From: Alison Meeus [REDACTED]
Sent: 01 October 2019 14:23
To: Simon Davis <Simon.Davis@arun.gov.uk>
Subject: RE: AW/237/19/PL Former Ship Inn

Thank you for sending on this e-mail. I have taken a look and would be grateful if you could please ask the applicant to provide further clarification on the following details:-

Drawing No:
B 102

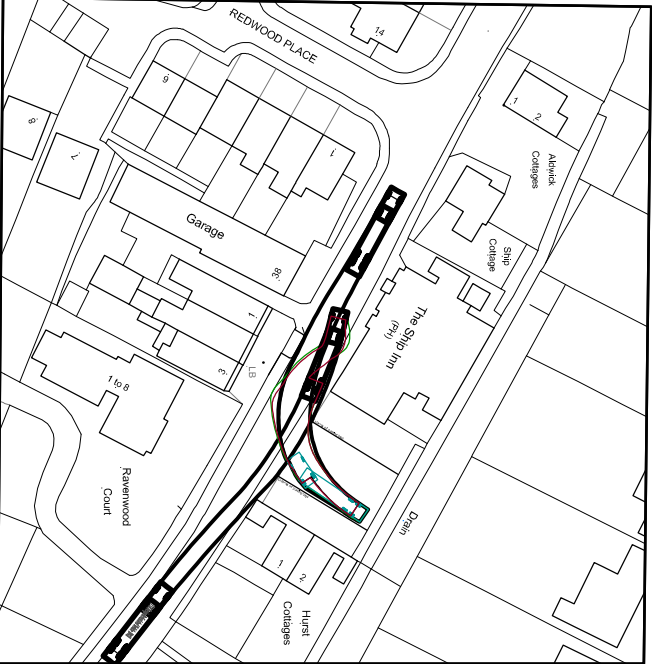
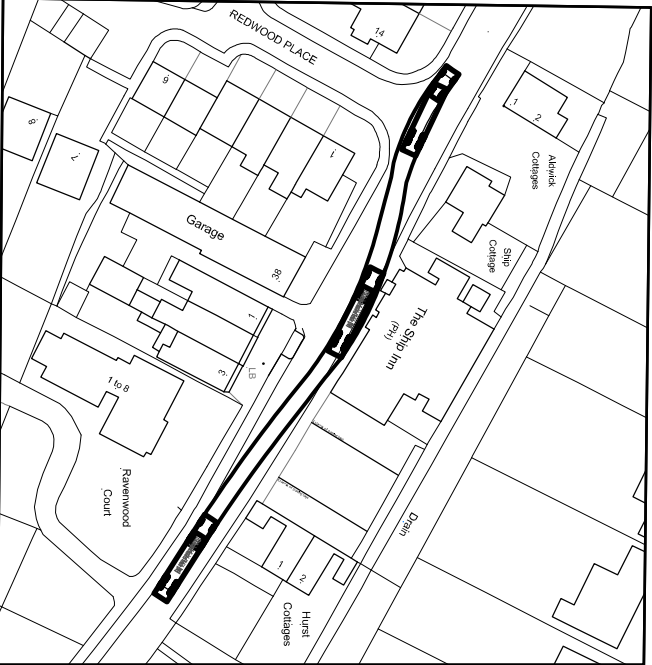
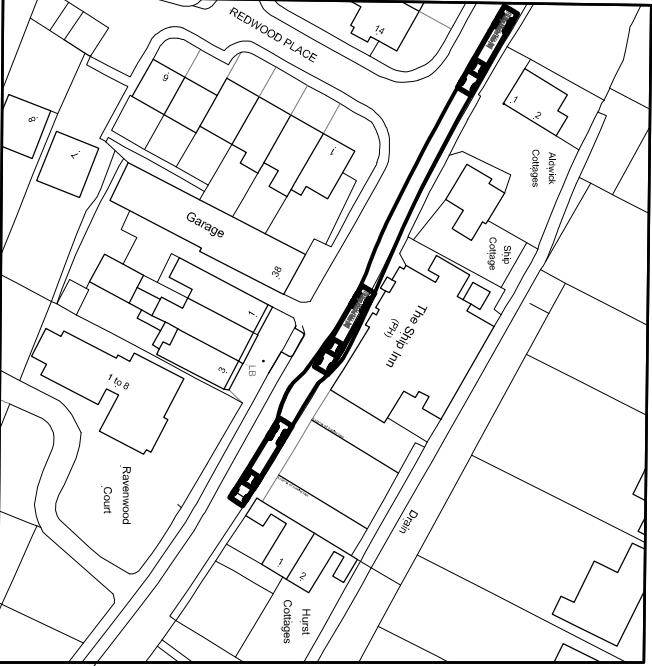
- 2) An understanding of the times of day for the remaining deliveries (apart from the papers which have already been accounted for in the early morning) These should avoid any peak hours of use.

- 3) Identify alternative car parking area
- 4) Option 1 is preferable as loading and unloading can be undertaken within the site.
- 5) Although it is not the preferred option, option 2 seems achievable however we need to understand if the highway will be able to operate as a result of the vehicles position. As such please can you include a swept path of a car using the highway at the same time the loading area is in use.

B 103

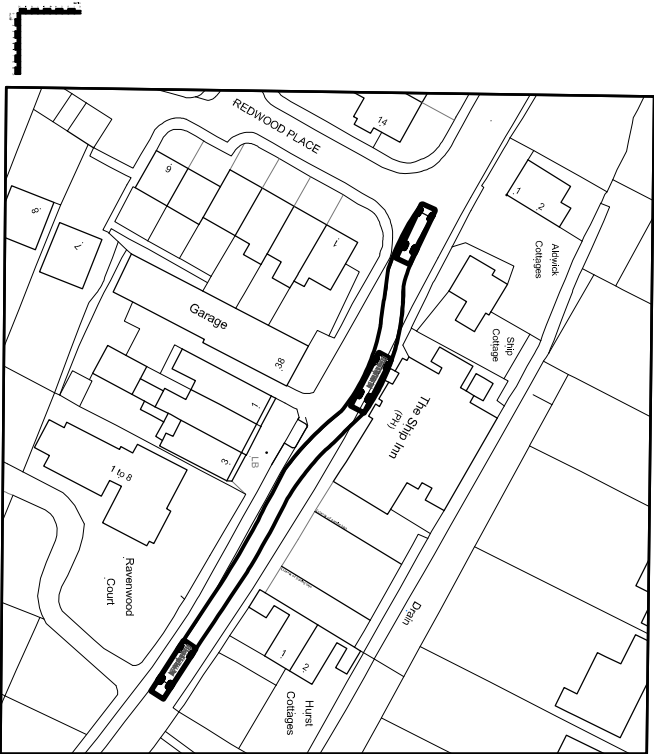
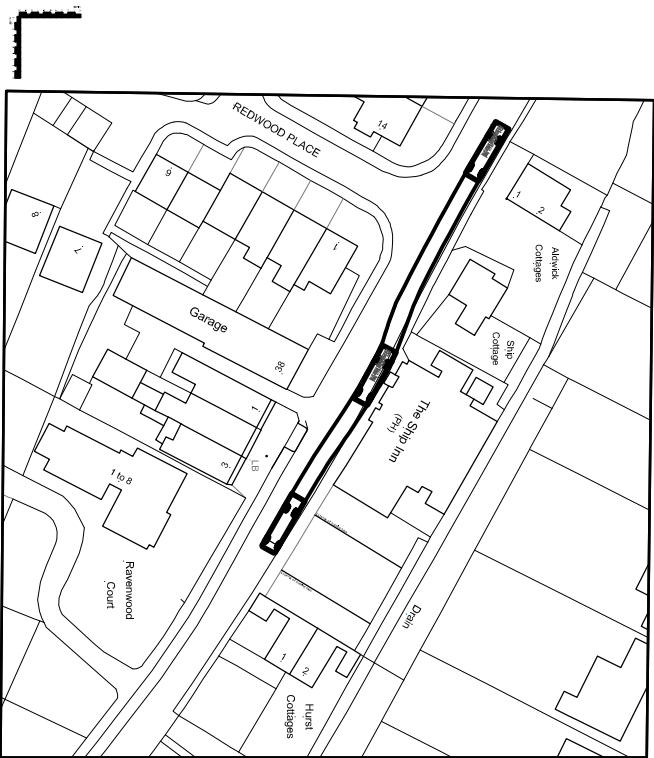
- 6) Although the swept path diagrams take into consideration the build out, there are also improvements to the northern section of highway. It is noted that the location of the HGV would stop the informal crossing being used. Is there room for the delivery vehicle to keep clear of this at all?
